Ref.	Comments to Examining Authority's Questions from Bryan Robinson (ref 20028154)
Ex Q1.0.6	<p><i>Comments have been submitted from Interested Parties (IPs) with regards to the design of the proposed Wood Lane Junction. Please provide details of alternatives considered and explain how and why the design approach as submitted was determined.</i></p> <p><b>Comments:</b> I wish to reaffirm my belief that <u>both</u> the Wood Lane and Norwich Road junctions are over designed for considerations other than the dualling of this section of the A47.</p> <p>I asked the reverse question in my representation to the Planning Inquiry for the A47 Blofield to North Burlingham proposals (TR10040) as to whether the South Walsham junction was under designed against the designs for A47NTE. The reply to this representation is attached in the Appendix, which concludes that a <u>compact</u> grade separated junction caters for the traffic flows and constraints.</p> <p>It is regrettable that there is not a requirement for <u>standardisation</u> of existing and predicted traffic numbers (including full AADT, peak and off-peak levels) at ALL appropriate relevant locations applicable to each junction which

Appendix B: Wood Lane Junction showing connection to Norwich Western Link (in pink)

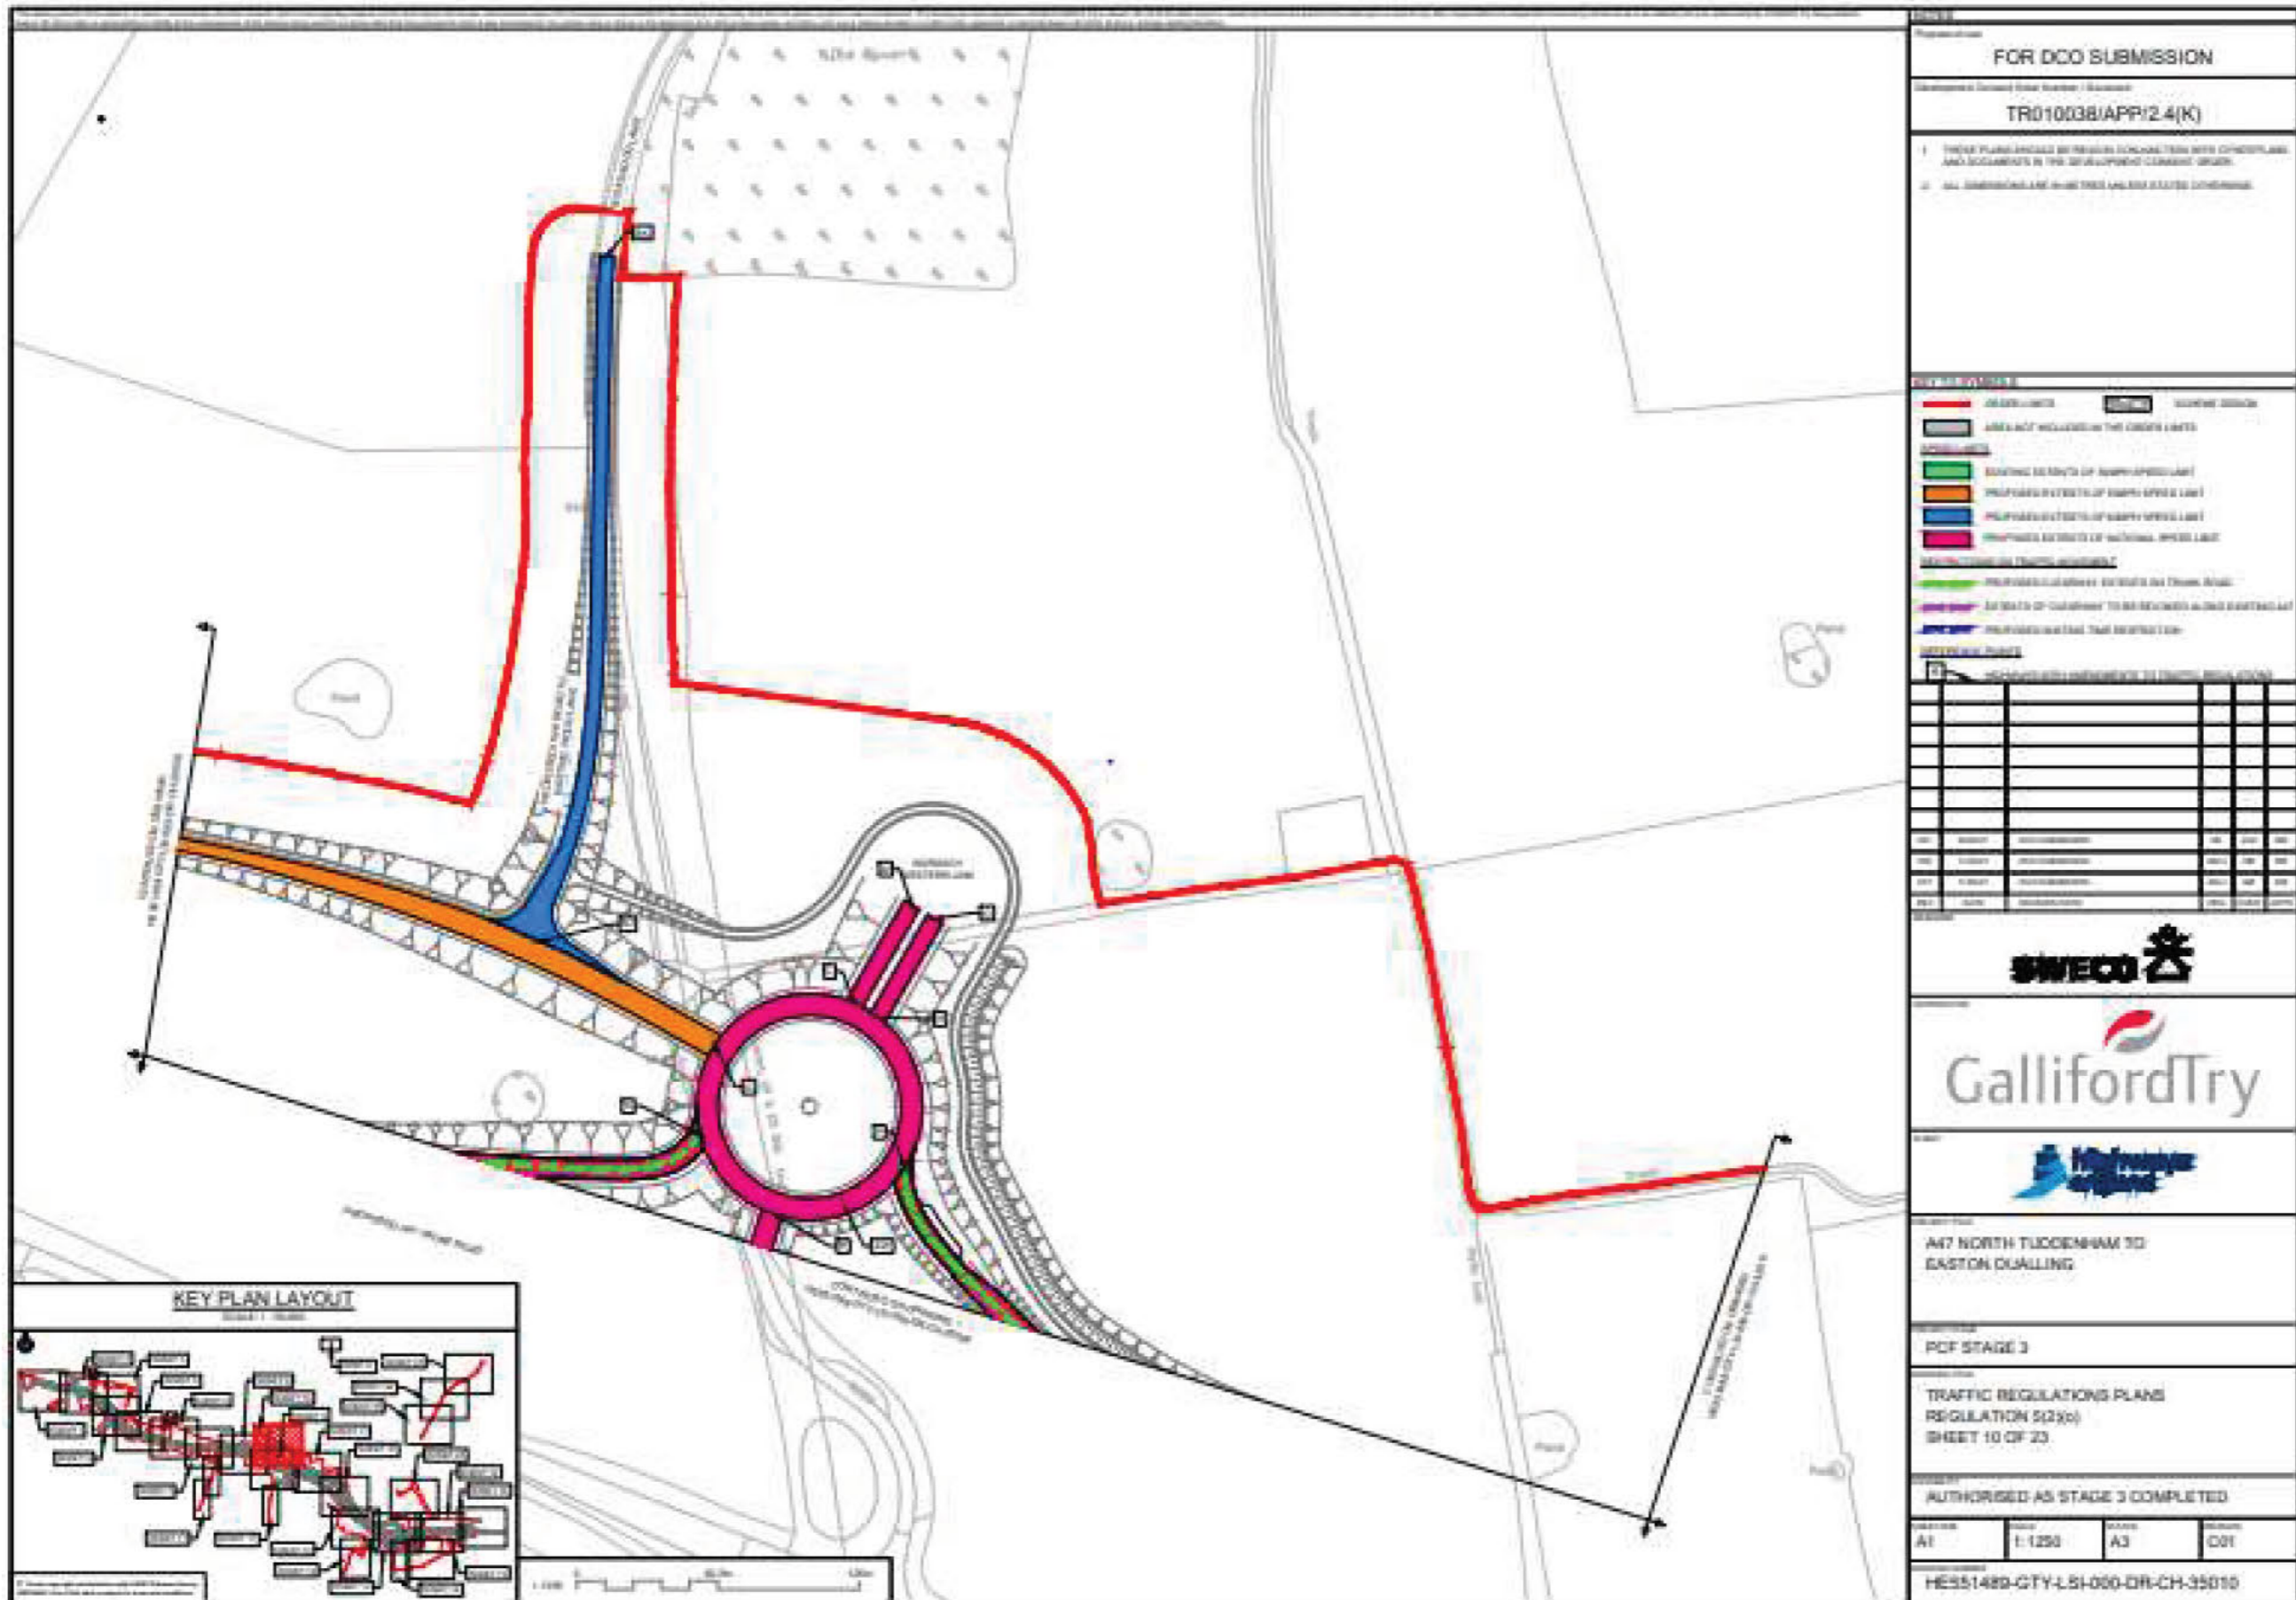
<p>NWL project by NCC detracting from the basic environmental effects of an upgrade to the Strategic Road Network. The A47 design is based on the assumption of the NWL being part of the overall changes which have influenced the traffic predictions and junction designs. The assumption that there is no in-combination effect of the two schemes would appear to be based on the fact that details of the works for the NWL “are not yet known” and that the NWL will have to account for the cumulative effects of the A47NTE in that planning process. One of the tenets of the NWL is that it is not dependent on the A47 upgrade and therefore, when it is eventually considered at its planning application stage in 2022, it will not be appropriate to consider the implications of the A47NTE works, if previously approved.</p> <p>However, HE has proposed a design based on the traffic levels from the NWL. The statement that the NWL connection can be omitted if that scheme does not proceed has no relevance without a revised base design as dictated by the existing lower traffic numbers associated with the several existing junctions and/or as rationalised by the side road strategy. My contention is that this would differ significantly from that with the concentration of all north/south traffic via the NWL. Currently the proposed side road strategy is dependent on the NWL and this is also likely to have to be revised if the NWL does not proceed.</p> <p>Transparency would suggest that the A47 scheme should be designed and costed against the requirements without the NWL. An alternative against a possibility of the NWL can then be considered and the changes in both environmental effects and costs can then be determined and attributed accordingly. Currently any extra costs of construction and land purchase will be lost in the RIS1 budget but in order to assess the true cost and BCR of the NWL these extras should attributed to it.</p>
